From: Robert Findlay
Sent: 13 October 2014 10:29
To: Planning.Responses
Subject: FW: Please find attached amendment on planning application Ref: M/61/14/PL

APPLICATION NO: M/61/14/PL

Registered: 11-SEP-14
Site Address: The Litten Ancton Lodge Lane Bognor Regis PO22 6LZ

Description of Works: Extension and conversion of existing residence into 3 No new flats & replaced and repositioned garage (resubmission following M/13/14/).

North Elevation (Proposed) 1:100

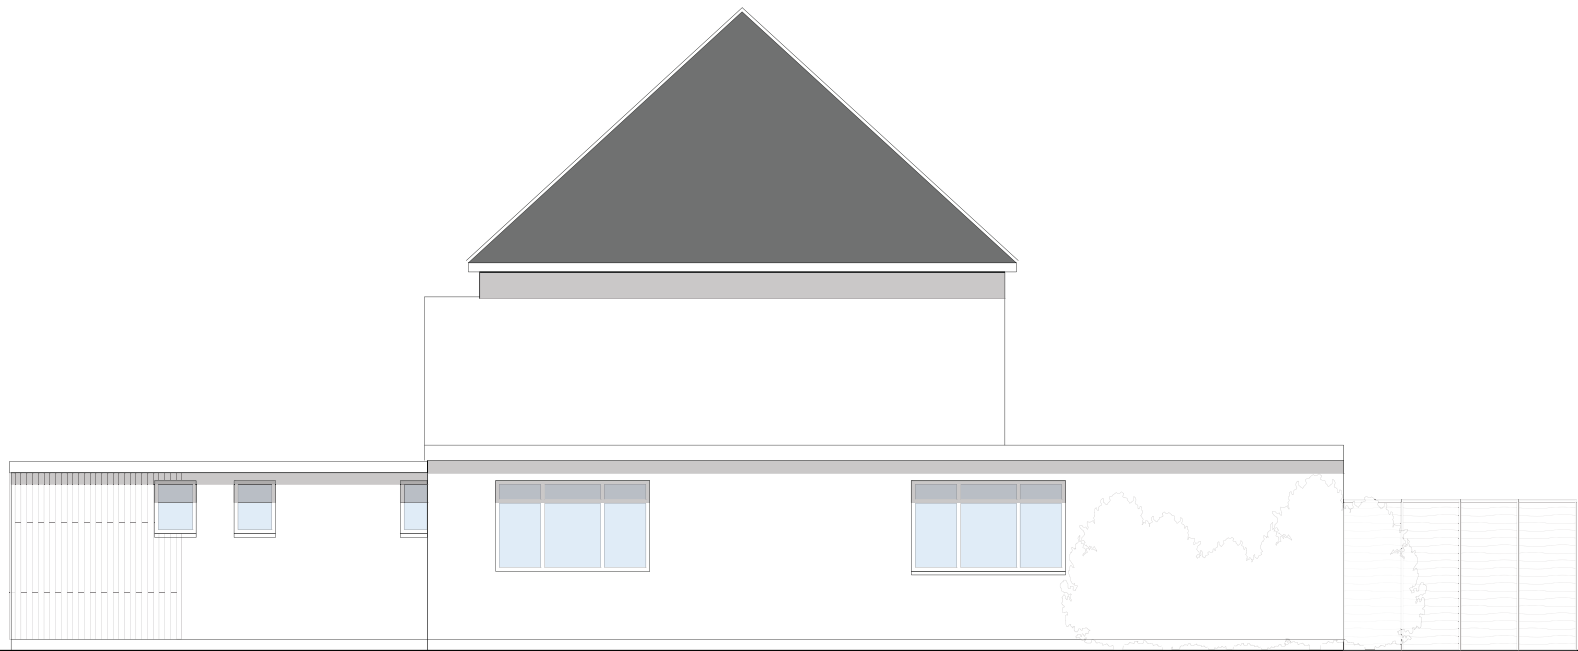
Fire resistant glazing will be required to windows on the north elevation as this appears to be the means of escape in the event of fire from the 1st floor
